KITTITAS COUNTY COMMUNITY DEVELOPMENT SERVICES

Date: September 16, 2020

Subject: Siderits Mini-Storage Pre- Application Meeting, CDS Planning Notes

This memo is in regard to the proposed 18' x 120' mini storage building on parcel 281634. The proposal has been reviewed for compliance with Kittitas County Code (KCC). After review of the submitted materials provided for this pre application meeting, CDS has the following comments.

7-90 STORAGE
PARCEL 80-11-11-20-0-0
EASTON, KITTEN'S Co., WA
SCALE 1" = 25' PARCEL 2816.34

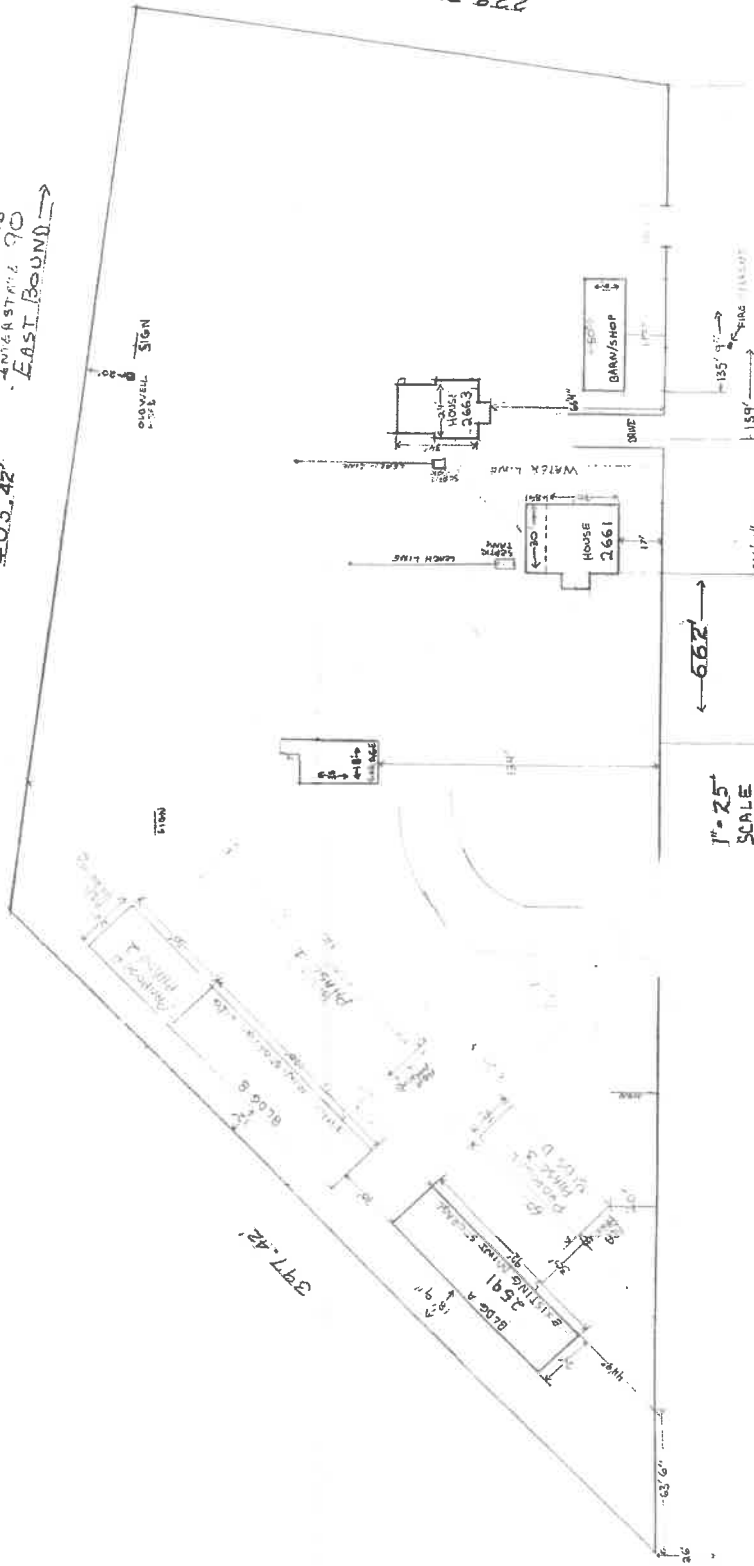
1. A mini-warehouse proposal (application) must include plans for aesthetic improvements and/or sight screening;
2. All buildings with storage units facing property boundaries shall have a minimum setback of thirty-five (35) feet;
3. No commercial or manufacturing activities will be permitted within any building or storage unit;
4. Lease documents shall spell out all conditions and restrictions of the use;
5. Signs, other than on-site direction aids, shall number not more than two (2) and shall not exceed forty (40) square feet each in area; and
6. In Type 3 LAMIRDS, the use shall be conducted wholly within an enclosed building.

The proposed addition of a 2,160 square foot storage building is below the square footage threshold (12,000 sq ft) for a SEPA review. The pre application materials provided do not indicate anticipated grade and fill for the project. The project is exempt from SEPA if it does not include grade and fill exceeding 500 cubic yards.
